2023/0781

Alta Vista, Lund Lane, Lundwood, Barnsley, S71 5PE

Erection of dormer, single storey rear extension, two storey porch, balcony to dwelling, garage conversion and supporting boundary wall

TITLE
BUNGALOW RENOVATIONS
PROPOSED ELEVATIONS

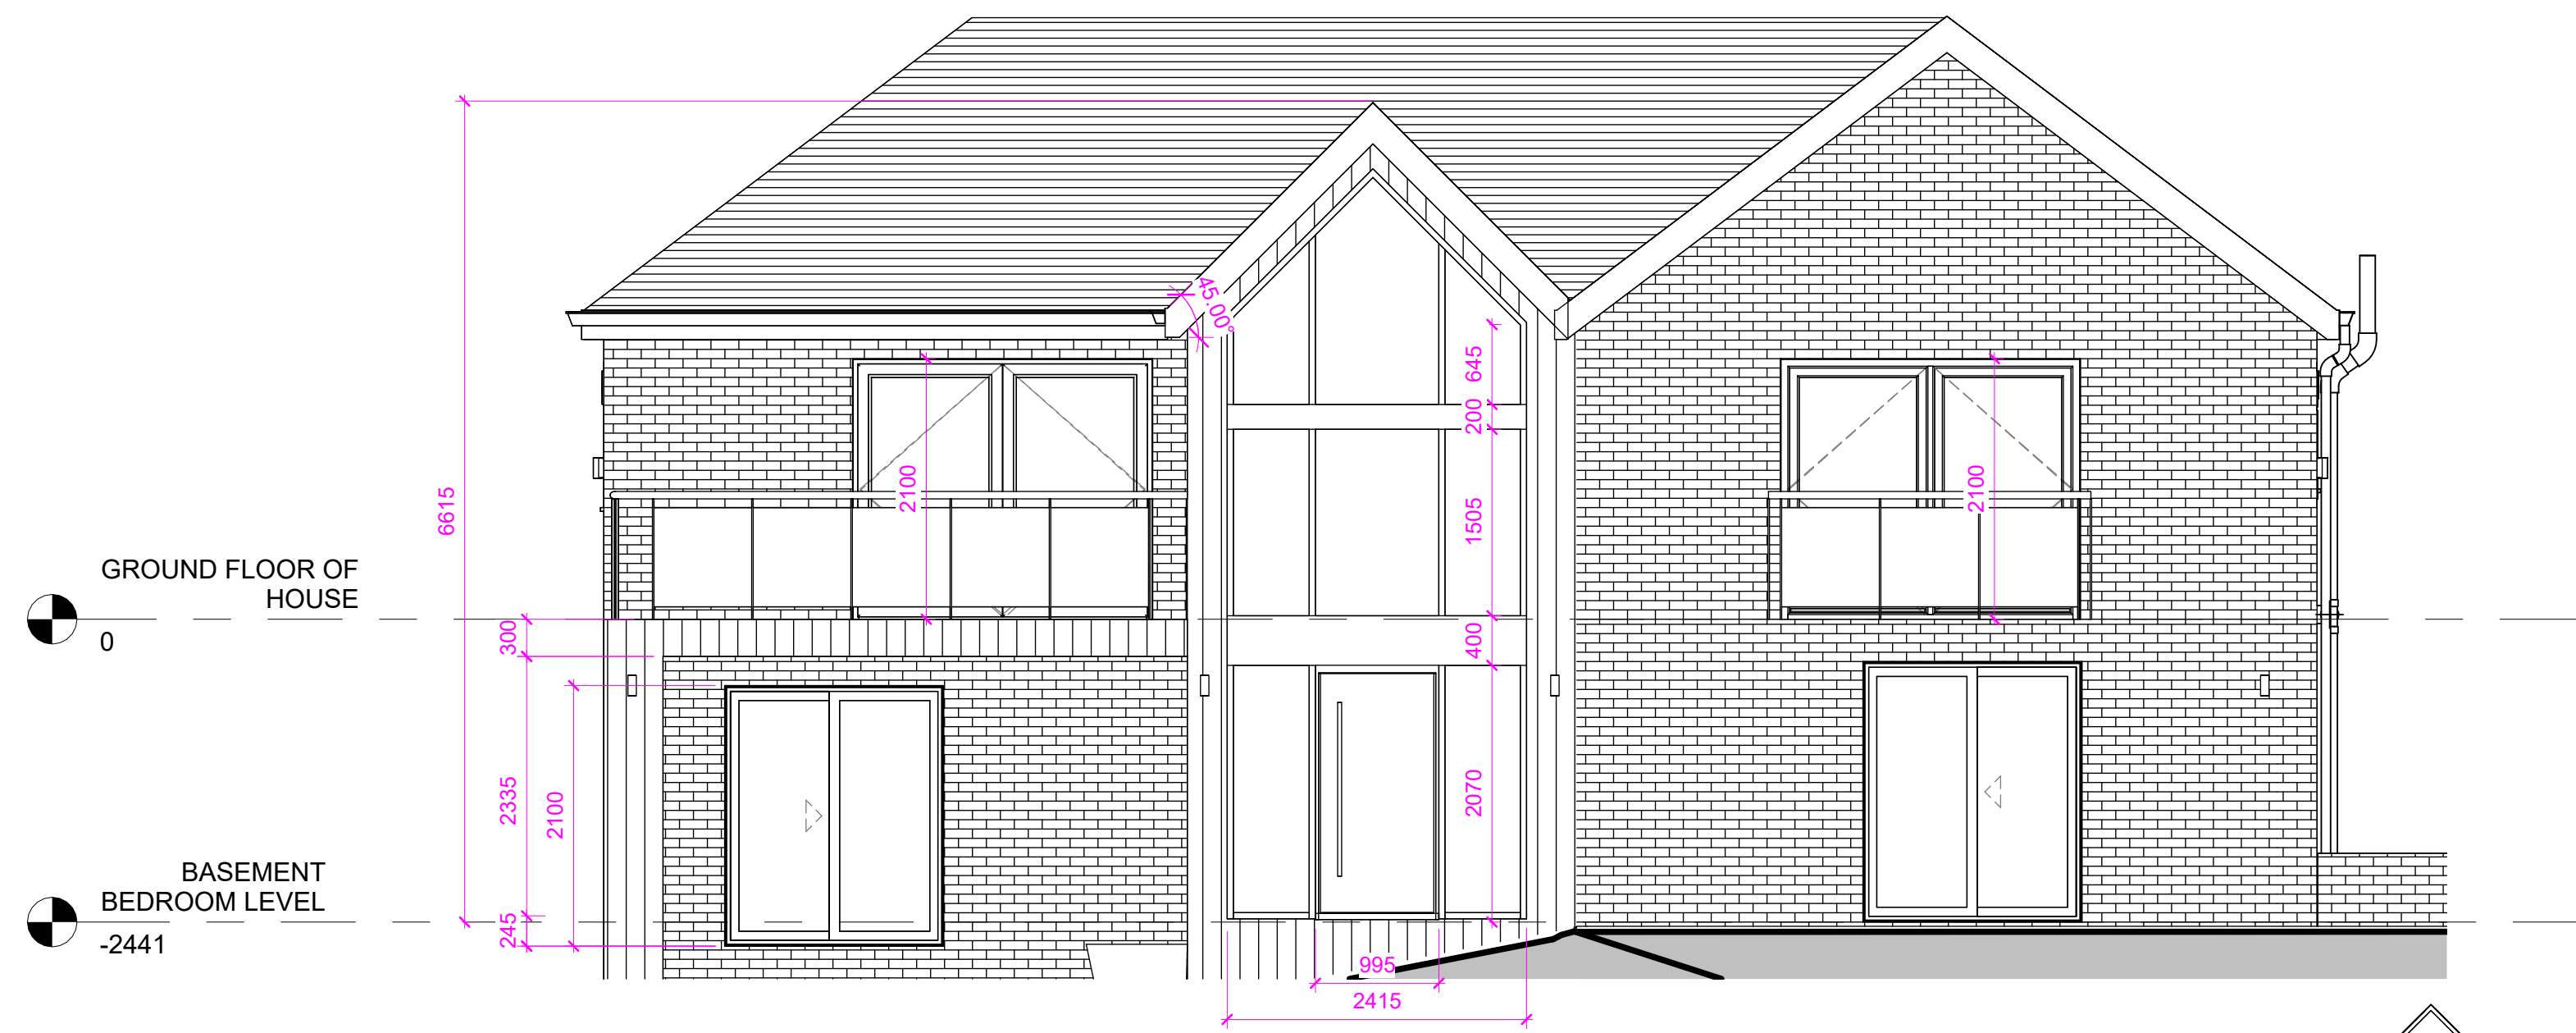
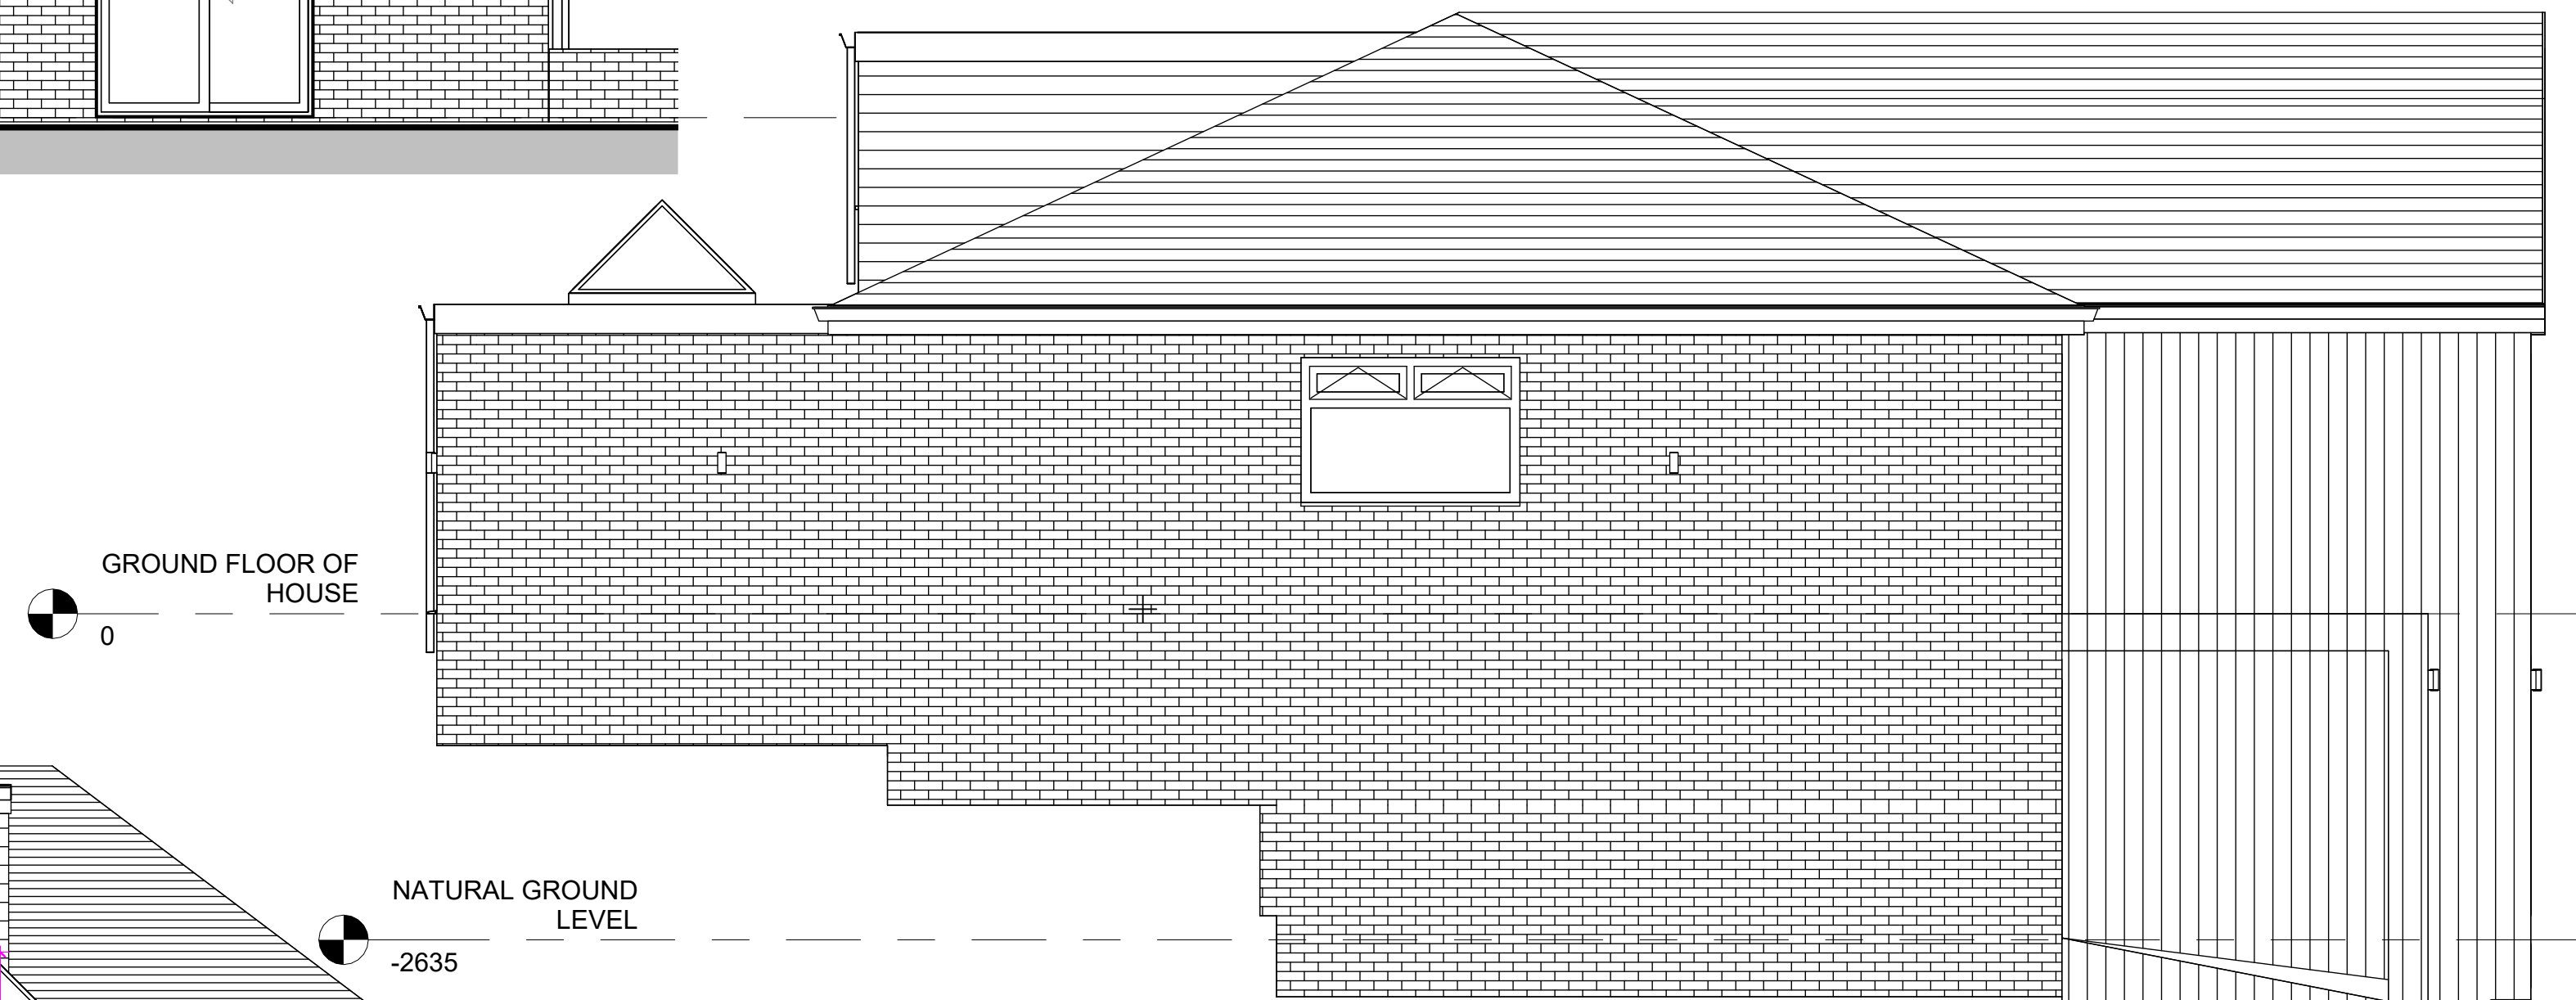
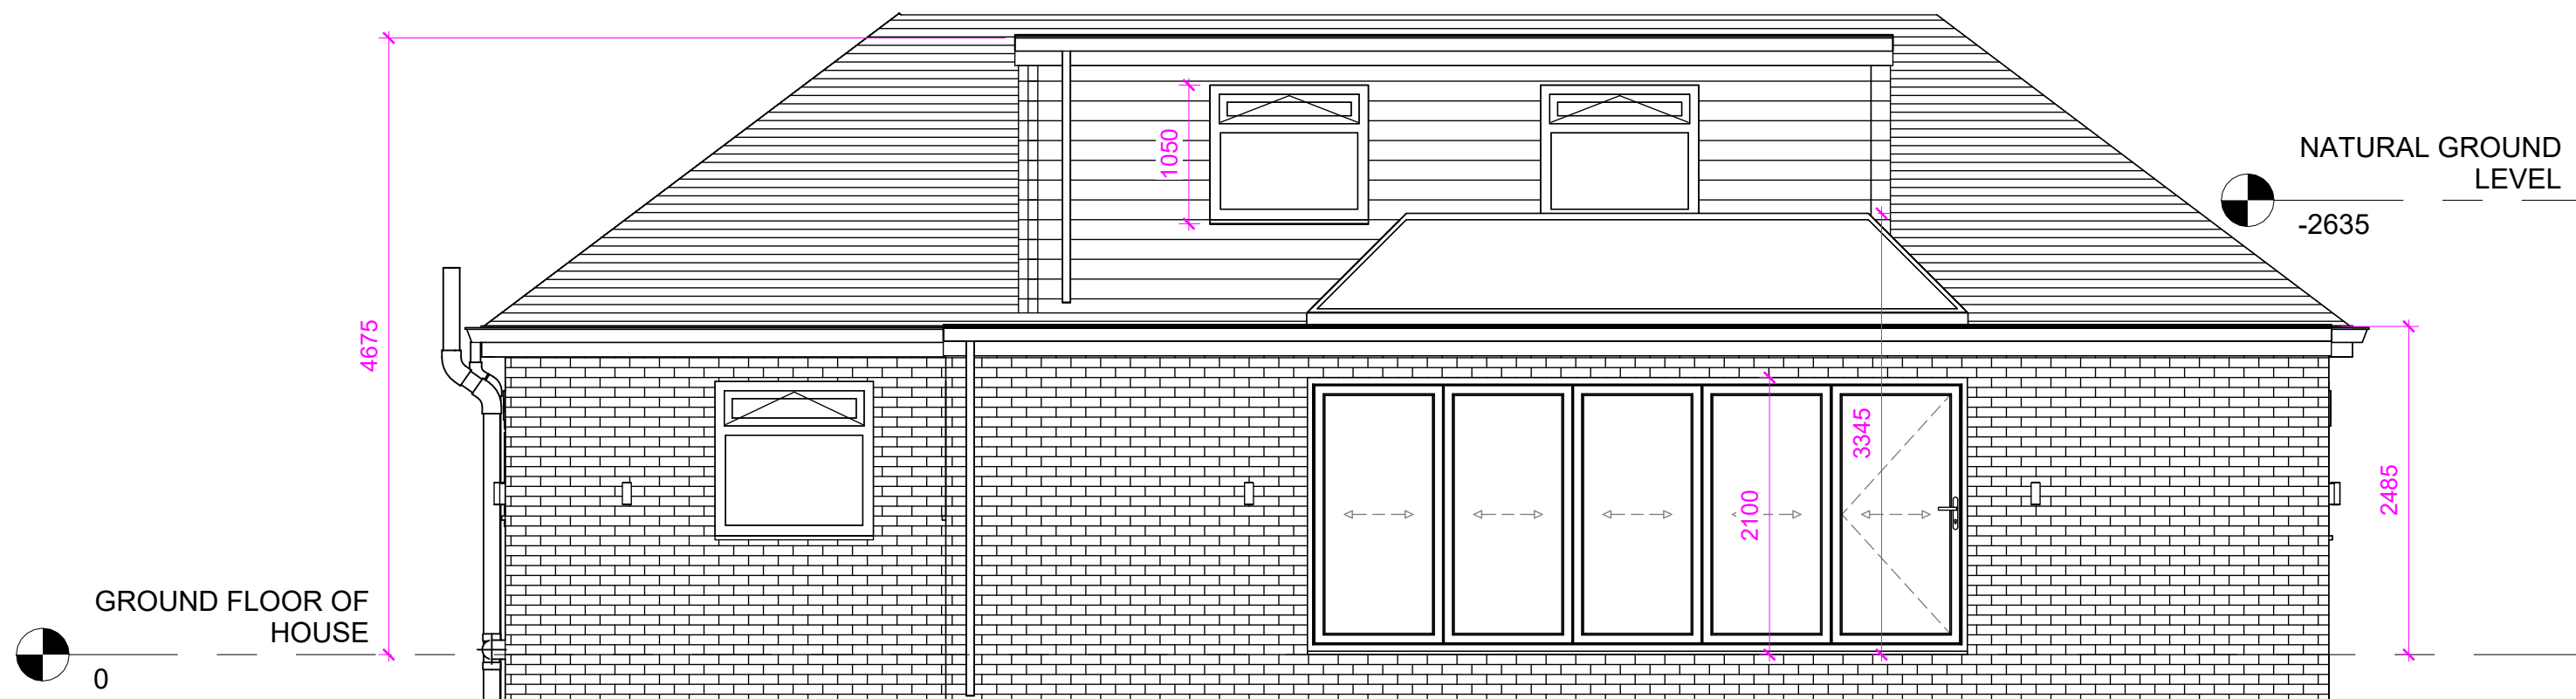
The SPD states that '*materials should normally be of the same type, colour and texture to the existing house or as close a match as possible*'. In this case, the majority of the proposed materials will be matching brickwork and roof tiles with the addition of some black cladding. This cladding is not deemed harmful as it will not be overly present on the front elevation. Also, all the dwellings on Lund Lane are individual and feature a range of contrasting materials therefore the proposed materials will not be harmful to the street scene of Lund Lane.

In terms of roof types, the front extension utilises a pitched roof which harmonises with that of the existing dwelling's pitched roof. On the other hand, to the rear a flat roof extension and dormer are proposed. Although flat roofs are usually not a supported roof type due to flat roofs being an inferior form of construction in this circumstance, they are acceptable as the dwelling is in essence single storey to the rear and they won't be visible from public vantage points or the street scene.
